## EL PASO COUNTY STORMWATER MANAGEMENT PLAN CHECKLIST

PPR244

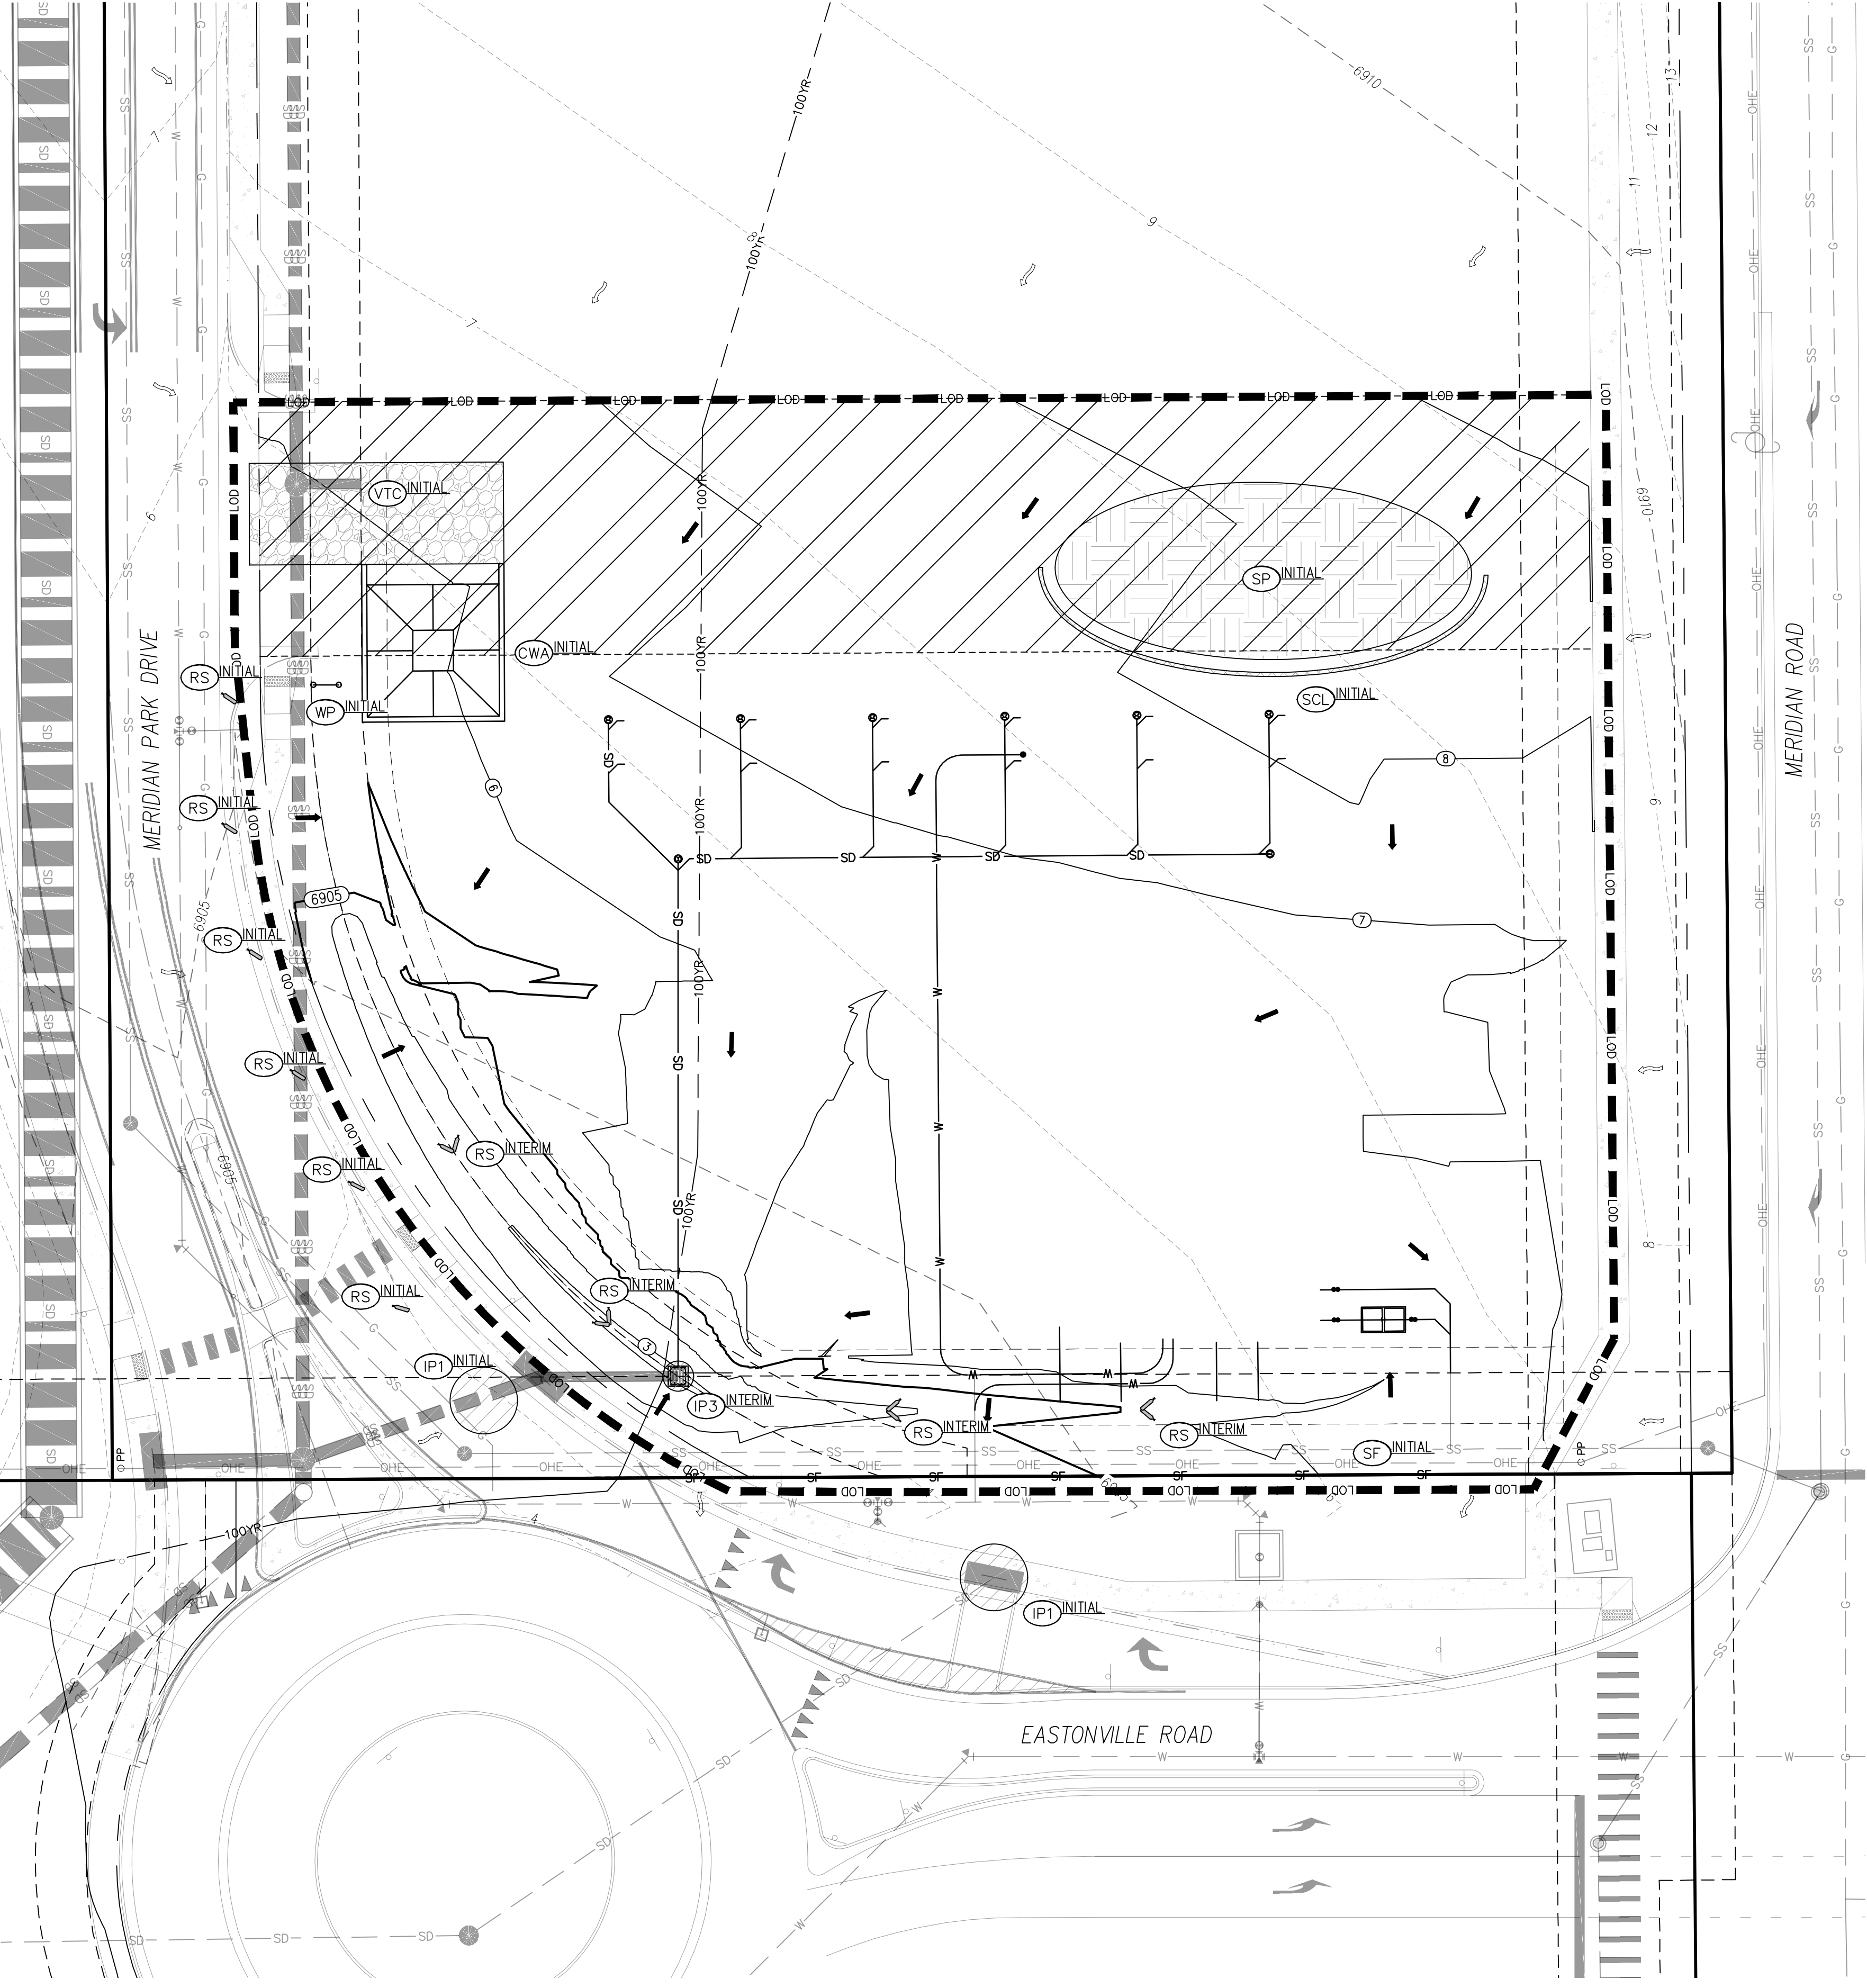
Applicant	EPC
17	SWMP Map to include:		
17a	construction site boundaries		N
17b	flow arrows to depict stormwater flow directions		Y
17c	all areas of disturbance		Y
17d	areas of cut and fill		Y
17e	areas used for storage of building materials, soils (stockpiles) or wastes		Y
17f	location of any dedicated asphalt / concrete batch plants		Y
17g	location of all structural control measures		Y
17h	location of all non-structural control measures		Y
17i	springs, streams, wetlands and other surface waters, including areas that require maintenance of pre-existing vegetation within 50 feet of a receiving water		Y
18	Narrative description of all structural control measures to be used. Modifications to EPC standard control measures must meet or exceed County-approved details		Y
19	Description of all non-structural control measures to be used including seeding, mulching, protection of existing vegetation, site watering, sod placement, etc.		Y
